Our Reference: SYD19/00717  
DPI&E Ref: SSD 10339

**PRINCE OF WALES HOSPITAL ACUTE SERVICES BUILDING  
HOSPITAL ROAD, RANDWICK**

Reference is made to the Department's correspondence dated 23 August 2019, requesting Roads and Maritime Services (Roads and Maritime) to provide comment.

Figure 11: Alternative traffic routes for the closure of Hospital Road at High Street

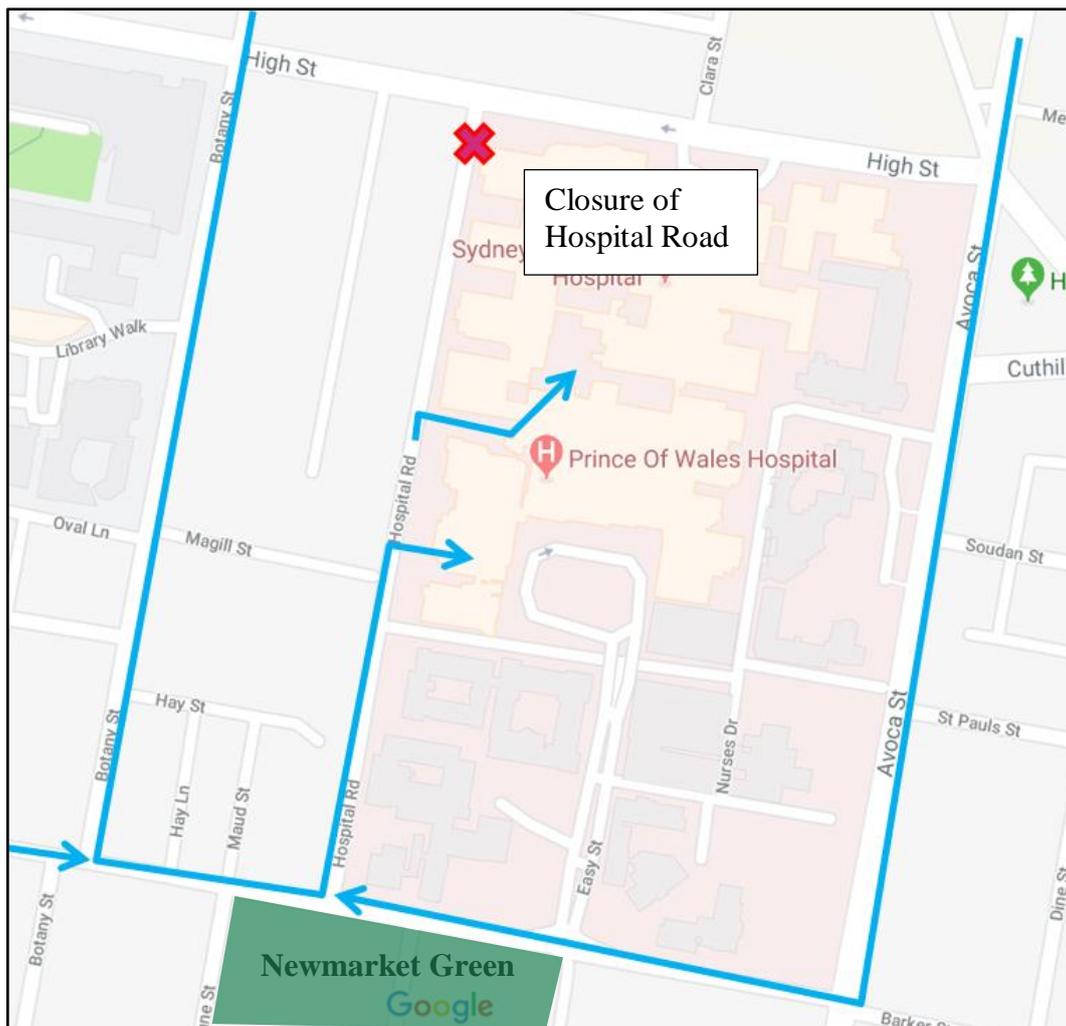
1. The lowering of Hospital Road and closure of Hospital Road from Barker Street to High Street will have an impact on existing traffic distribution on the surrounding transport network. Roads and Maritime has reviewed the submitted Transport Impact Assessment (TIA) and notes an increase in trip distribution to McGill Street and Botany Street.

As such, Roads and Maritime requests that the applicant continues to engage with the transport cluster to identify measures to mitigate any impacts to the surrounding network.
